**From:** [REDACTED]  
**To:** [M42 Junction 6](#)  
**Cc:** [Bartkowiak, Bart](#)  
**Subject:** Philip O'Reilly - M42 Jct6 - Critique of Highways England Document - 6.3 Environmental Statement - Appendix 12.4 - Reconfiguration of Warwickshire Gaelic Athletic Association  
**Date:** 24 June 2019 22:08:25  
**Attachments:** [Mr Philip O'Reilly - M42 Jct6 - Critique of Highways England Document - 6.3 Environmental Statement - Appendix 12.4 - Reconfiguration of Warwickshire Gaelic Athletic Association.pdf](#)

**Critique of Highways England Document:**

**6.3 Environmental Statement - Appendix 12.4 -  
Reconfiguration of Warwickshire Gaelic Athletic Association**

Drawing Title
FIGURE 12.1 NOISE LOCATION PLAN

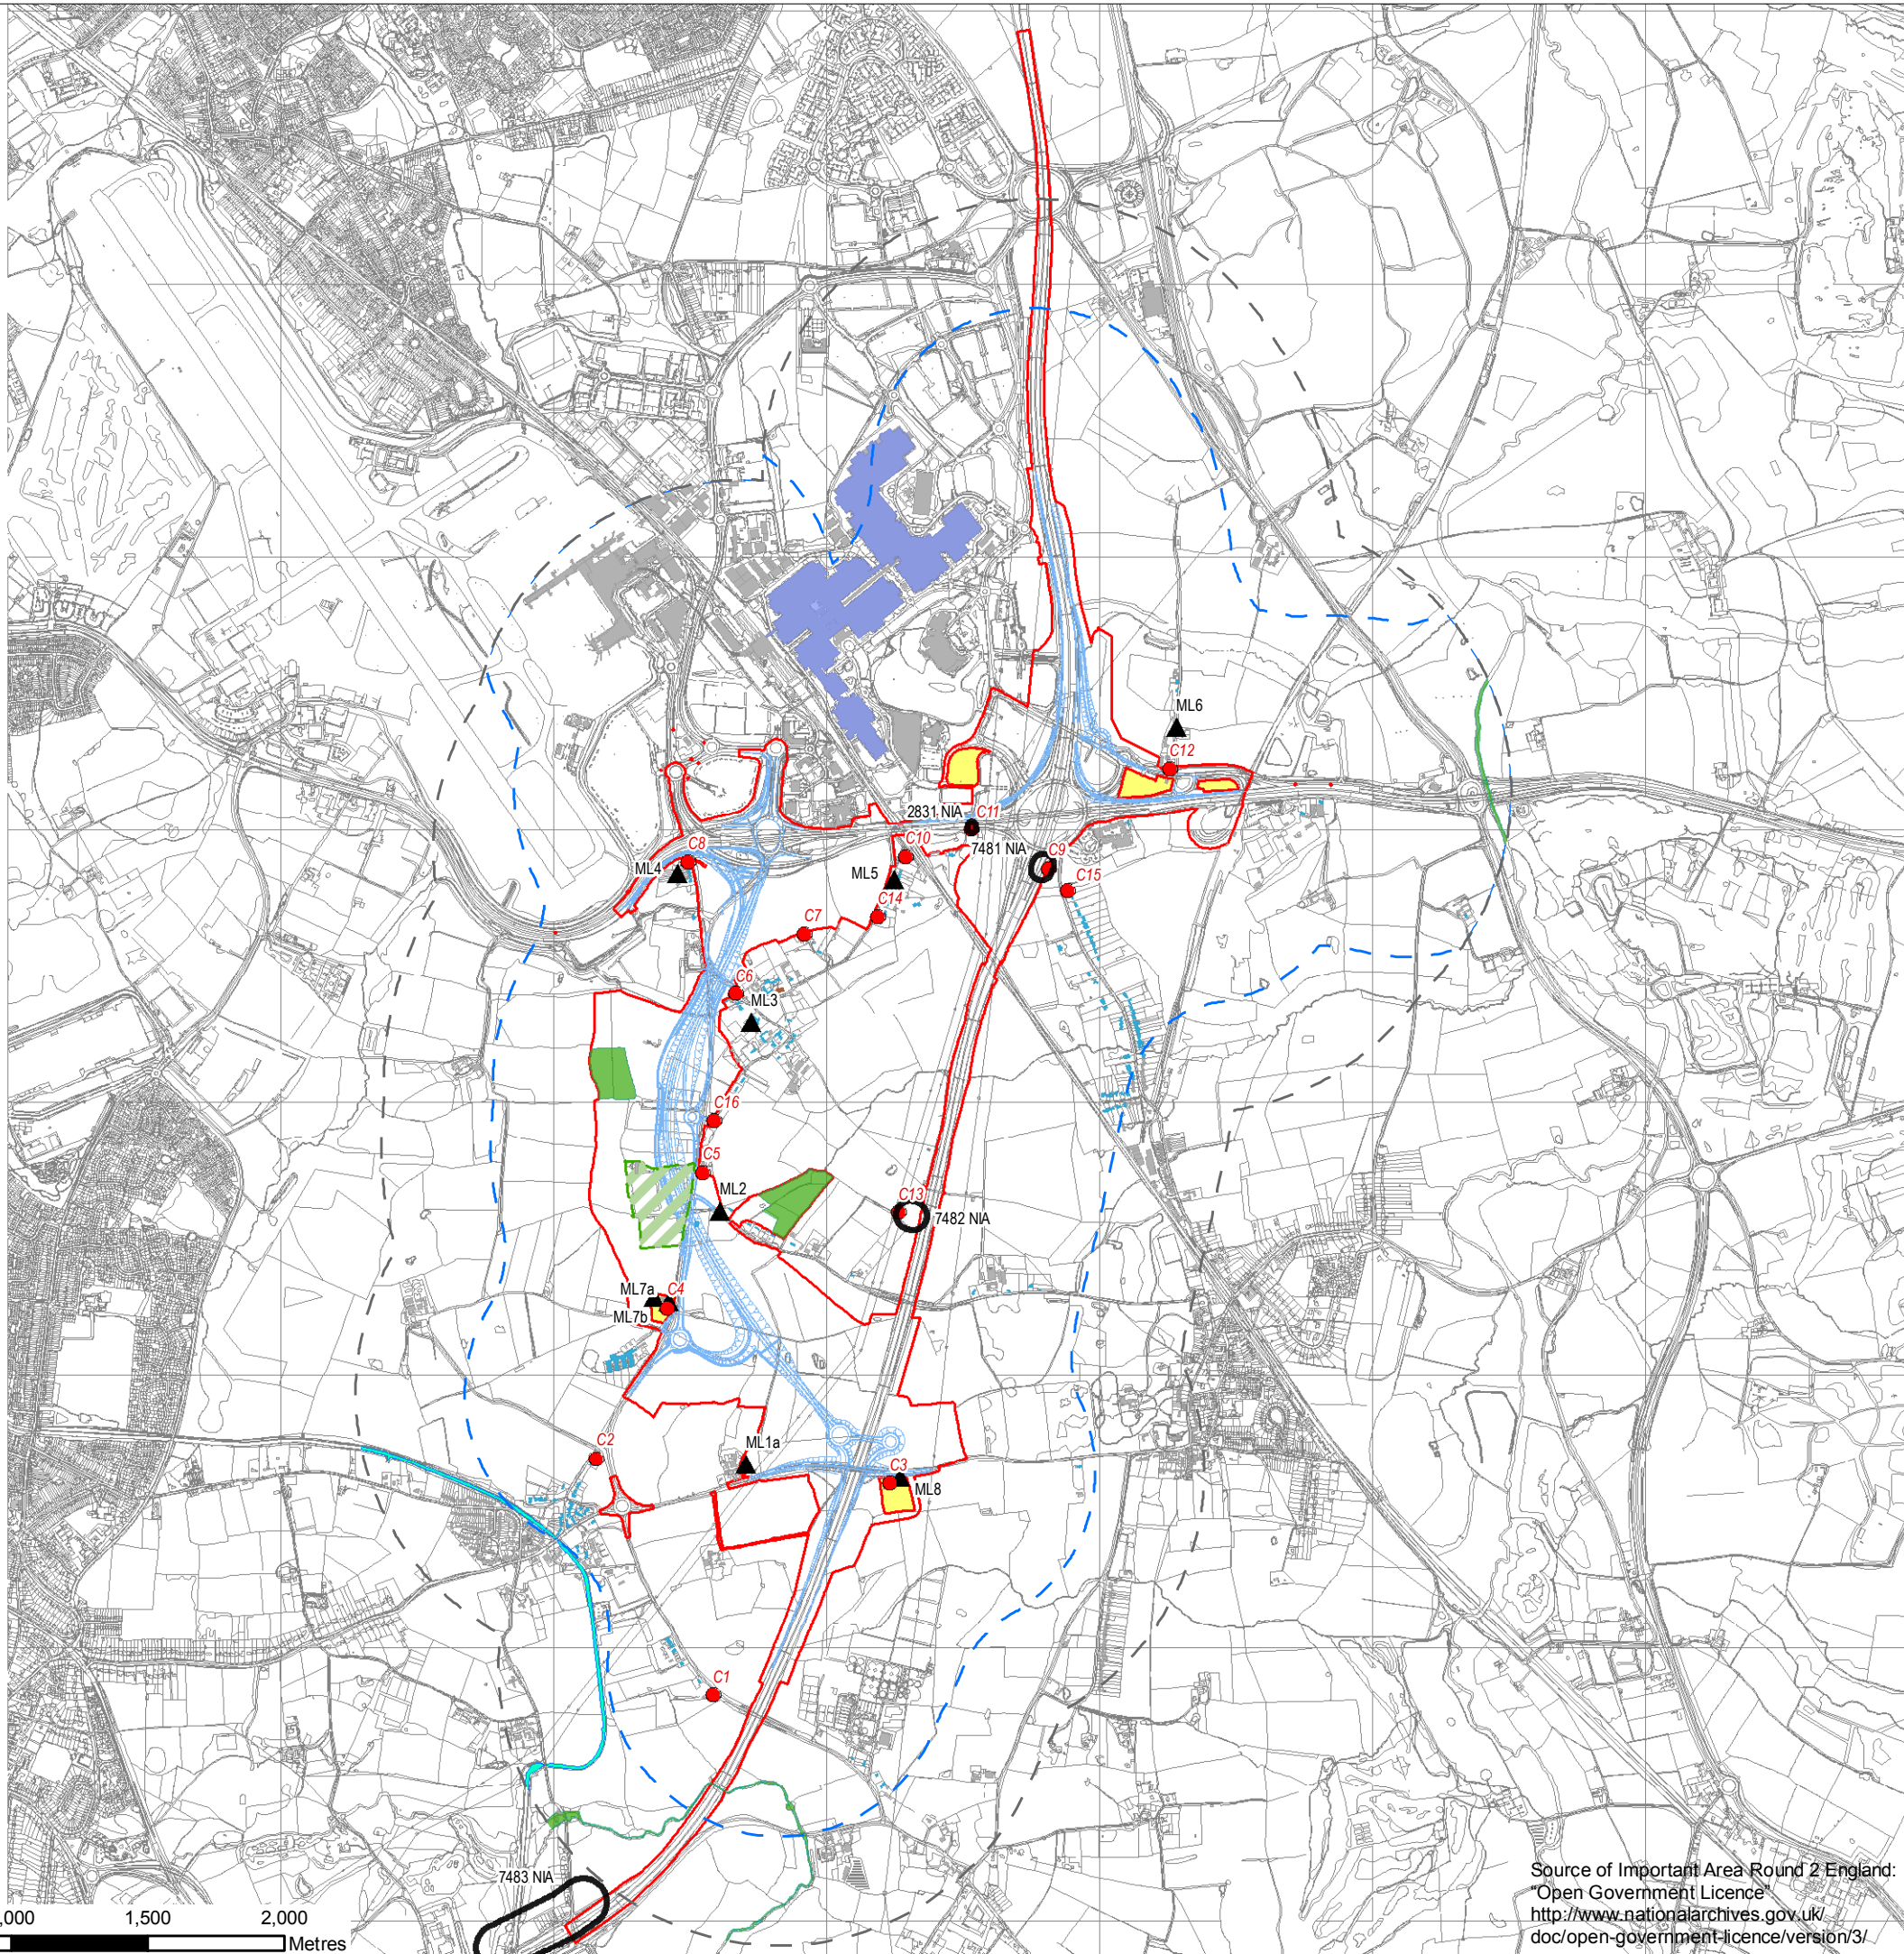
With regard to the WGAA reconfiguration, Volume 6 - Appendix 12.4 of the Environmental Statement compares the five options submitted with the DCO application against noise monitoring results taken at two locations - to the front and to the rear of Four Winds - but does not provide an accurate representation of the facts.

Section 12.4.1 advises that the existing noise climate data is recorded in Tables 1-4 to 1-6 (pages 4 to 6).

Section 12.4.2 confirms that weather conditions affected some results and wind speeds exceeded the recommended 5 m/s but average wind speeds did not exceed *'3 m/s for any daytime or night-time period'*.

HE have failed to include any meteorological data to support their statement, despite met office data confirming average wind speeds did in fact exceed the 5 m/s threshold on the following dates:

However, it is difficult to see where the data to support this statement has been included in the document. Monitoring Locations 7a and 7b (ML7a, ML7b) were installed at the front and rear of Four Winds. The tables 1-7 and 1-8 state a noise data level for Four Winds but do not differentiate between ML7a and ML7b. It has also been shown previously that the existing noise climate data submitted by HE is flawed and the true representative data is likely to be lower.
